Arun District Council  
Arun Civic Centre  
Maltravers Road  
Littlehampton  
West Sussex BN17 5LF  
Planning & Building Control General Enquiries  
Tel: (01903) 737756 Fax: (01903) 730442  
Dx: 57406 Littlehampton  
Minicom: 01903 732765  
e-mail: [planning@arun.gov.uk](mailto:planning@arun.gov.uk)  
website: [www.arun.gov.uk/planning](http://www.arun.gov.uk/planning)

30th October 2024

Application No: BR/180/24/PL  
Site Address: Winslade Court 10 Cavendish Road Bognor Regis PO21 2JW  
Description of works: Change of use from 8 bedroom House in Multiple Occupation (HMO) to 11 bedroom HMO. This application is in CIL zone 4 and is CIL liable.

Thank you for your internet representation made on 30th October 2024 which has been recorded as an objection with the comments as follows:

Drg. No. PG.9011 · 24 · 02 Rev. E

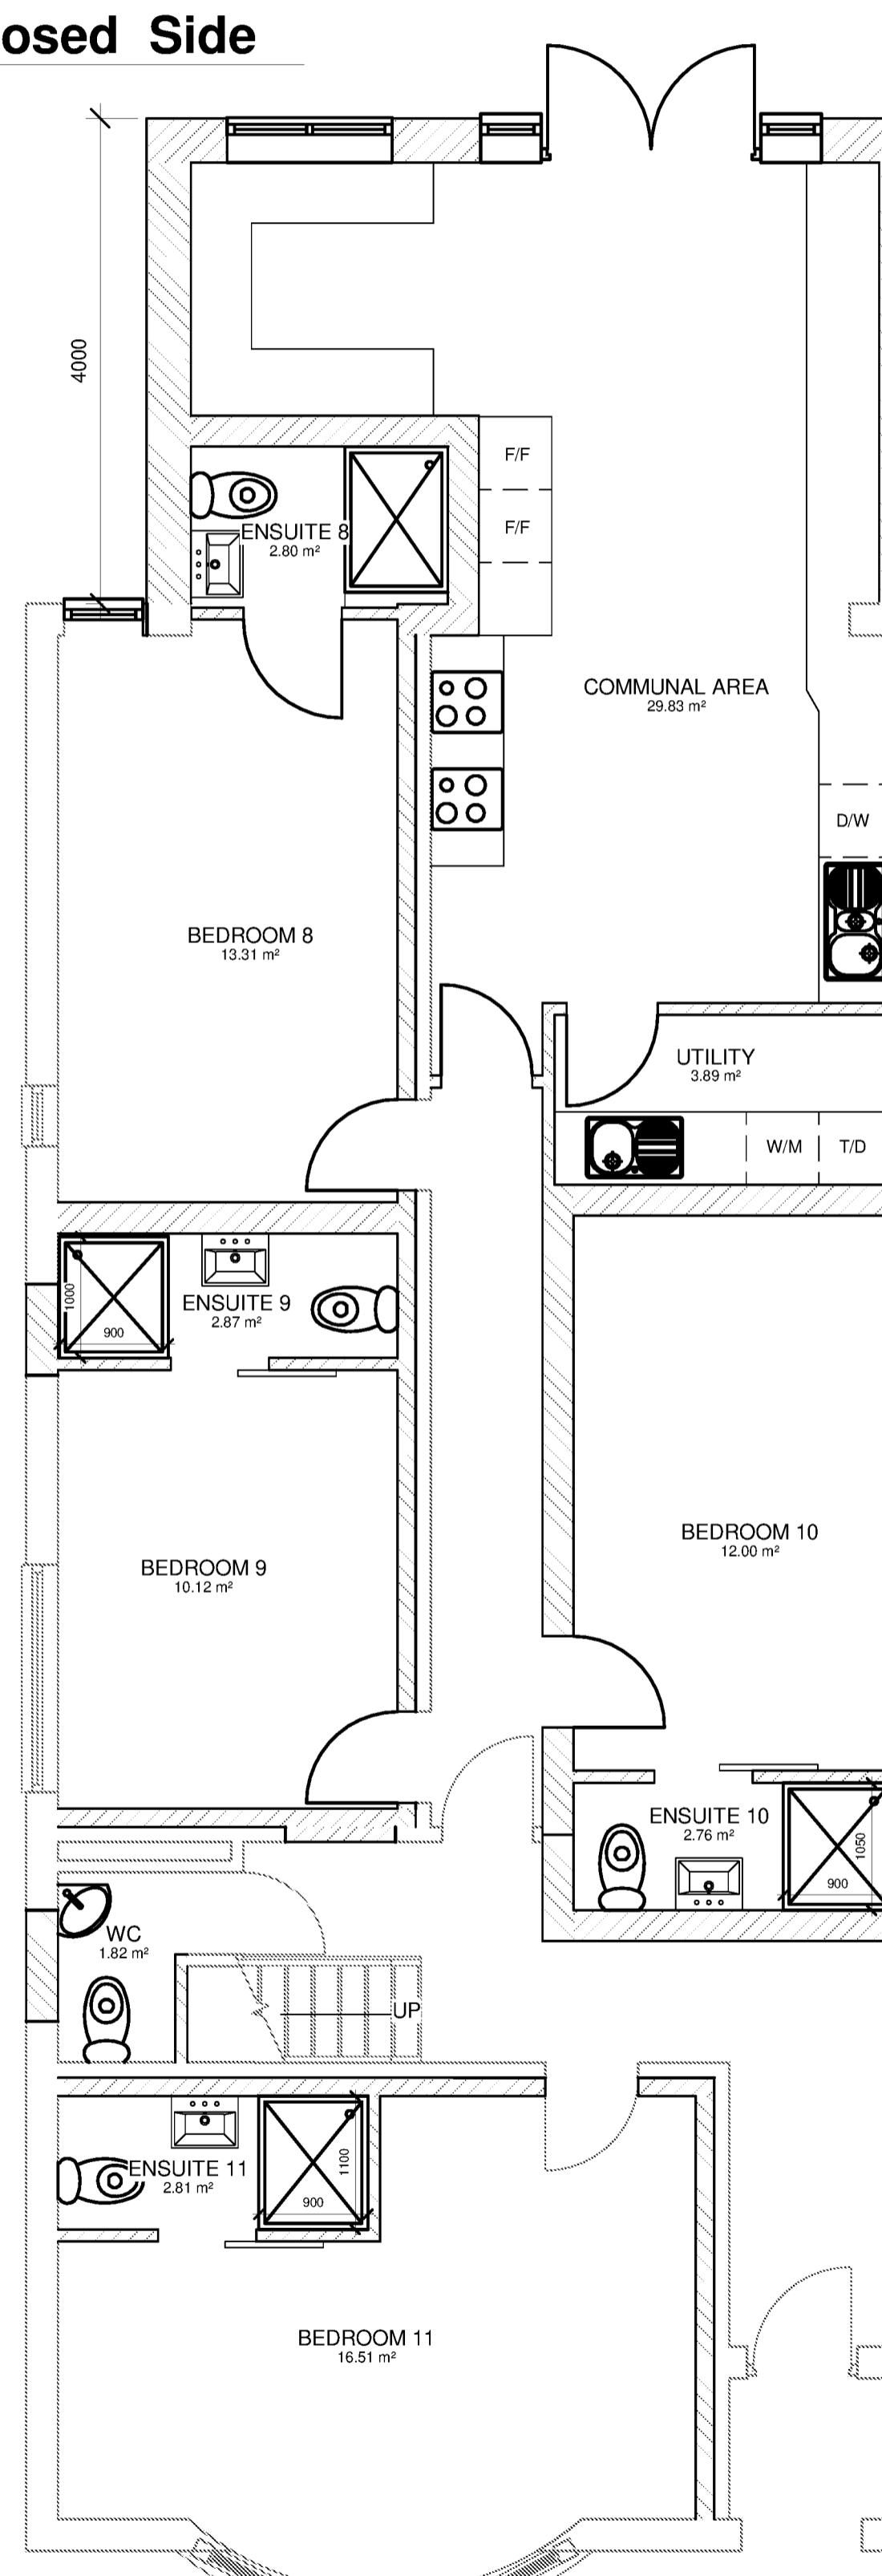
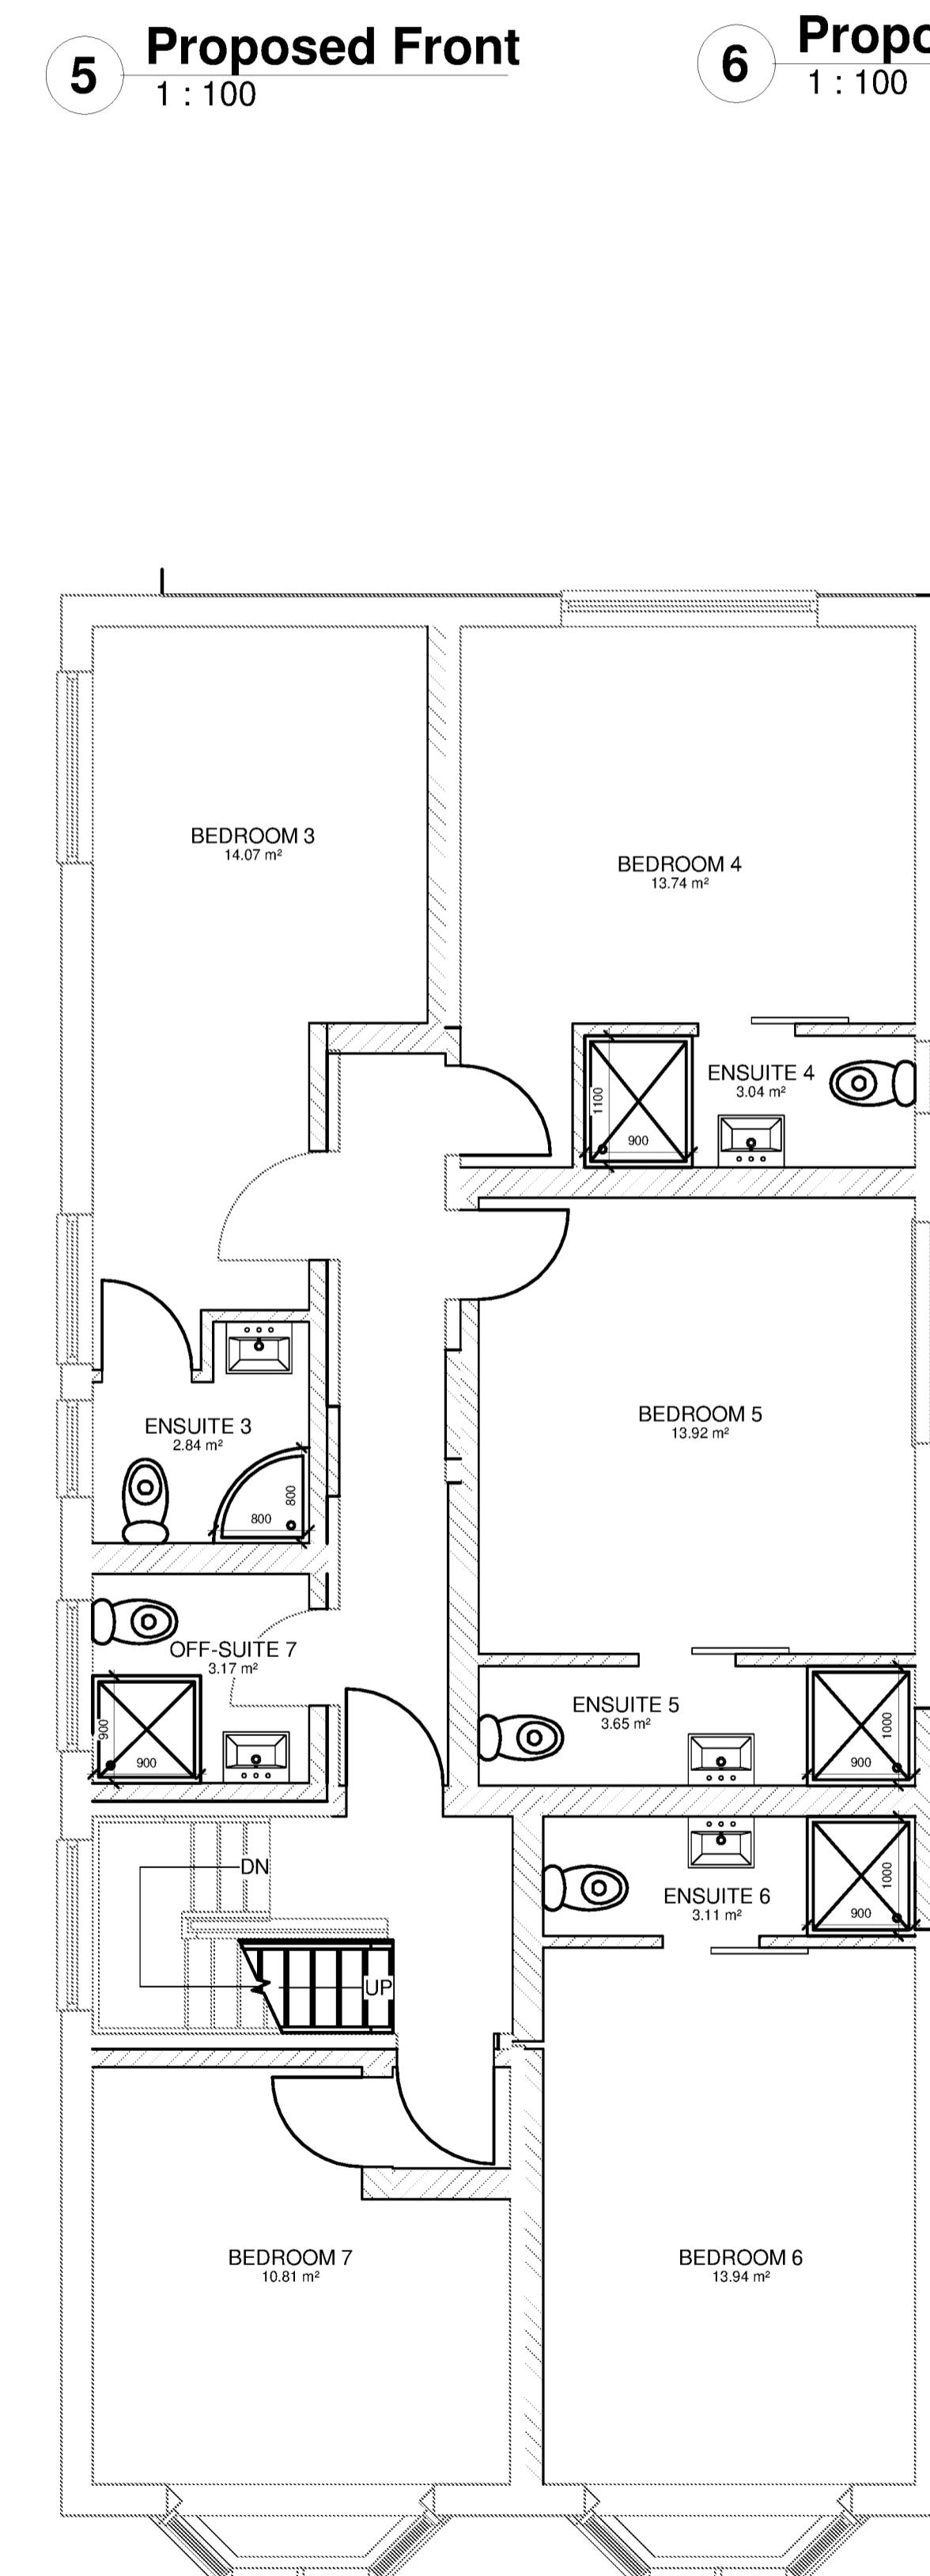
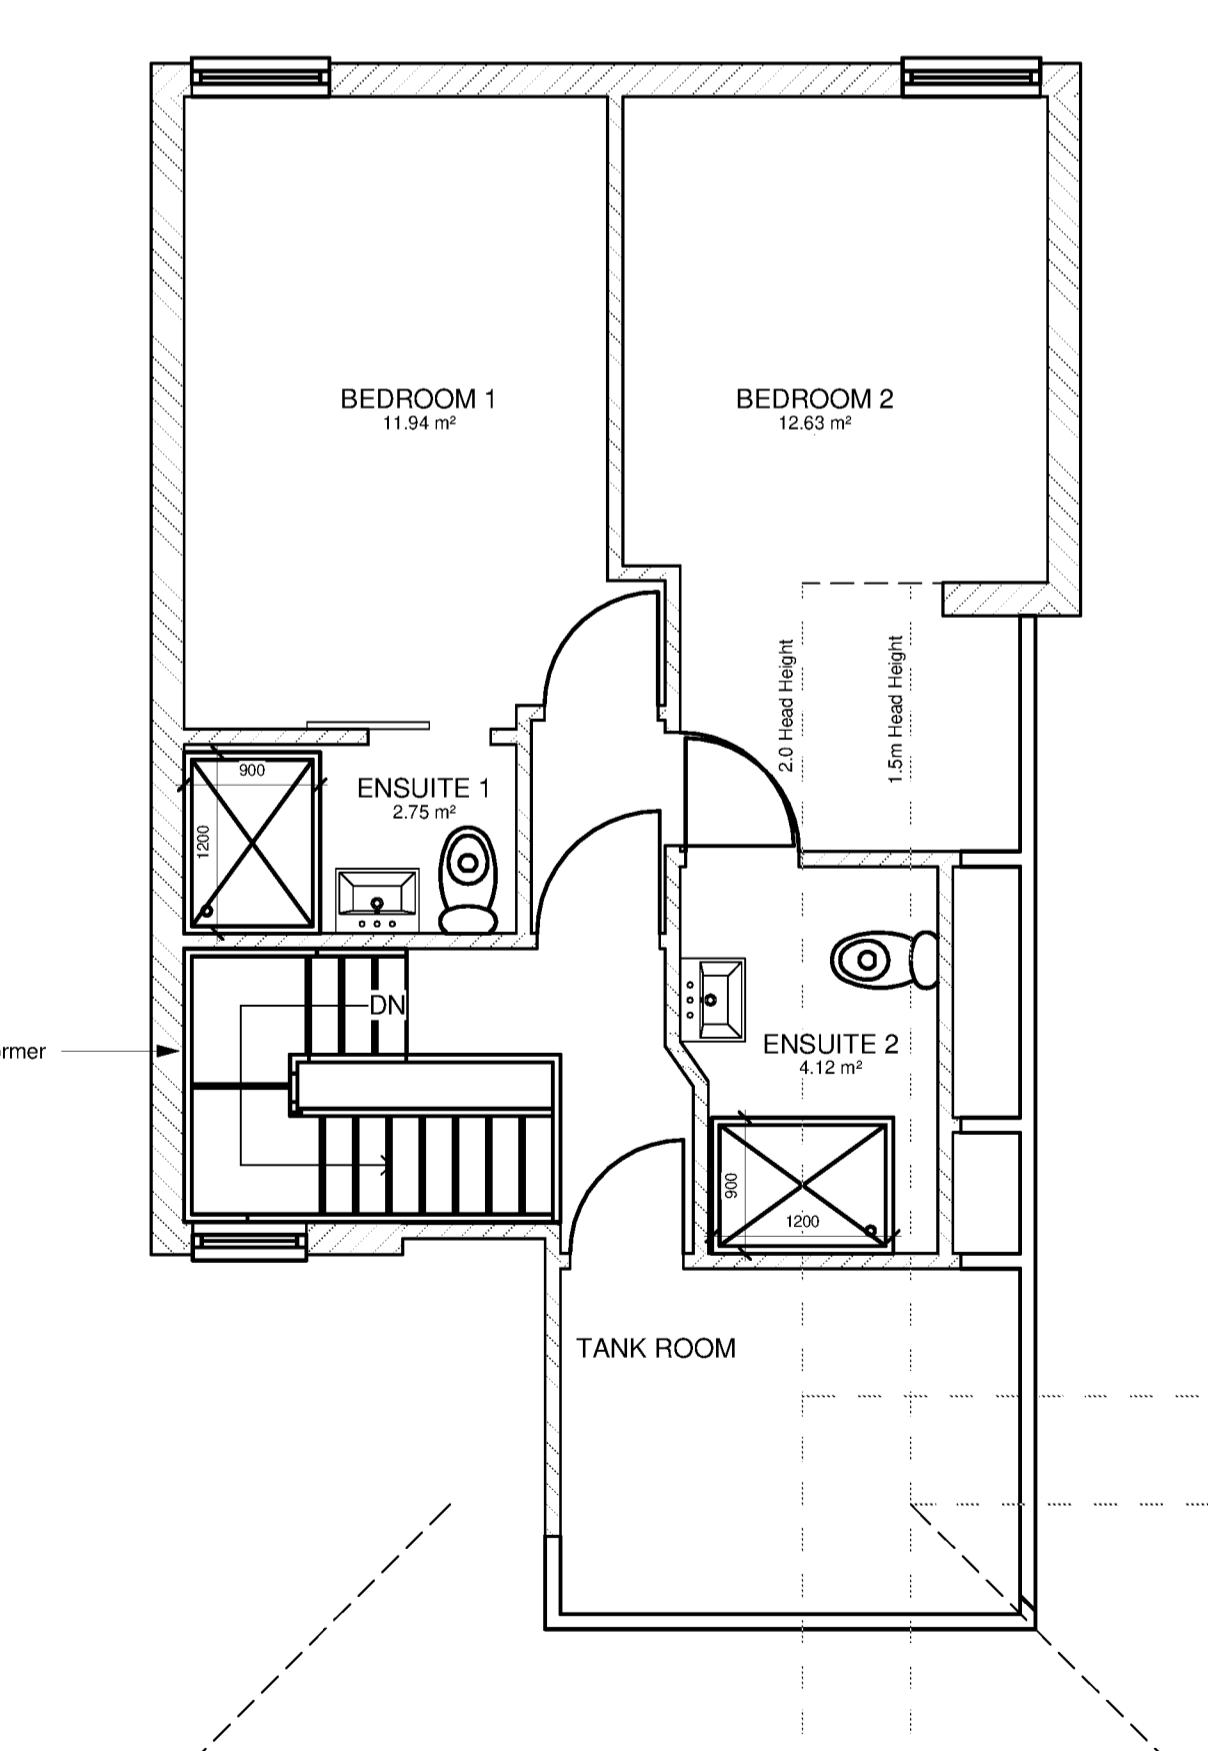
Members noted the comments of ADC Private Sector Housing and Public Health, particularly in relation to some of the proposed ensuite bathrooms and small windows in certain bedrooms. The proposed HMO by reason of the inadequate size of the bathrooms proposed would not provide a sufficient standard of amenity for the residents in conflict with policy HSP4 c) of the Arun Local Plan and the Arun Design Guide.

Drawing Title
Proposed Site Plan and
Bike Store

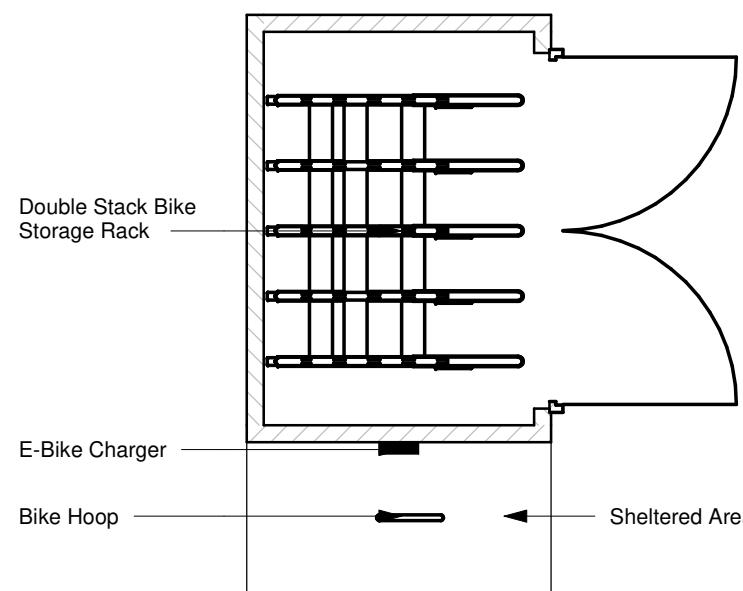
The proposal would result in a overdevelopment of the site through the proposed intensification of use which would result in the inability of the site to accommodate a sufficient provision of communal recycling bins and safe bin storage areas and secure and covered cycle storage facilities for the prospective occupiers, contrary

to policies H SP4, T SP1 and WM DM1 of the Arun Local Plan, Design Guide and the NPPF.
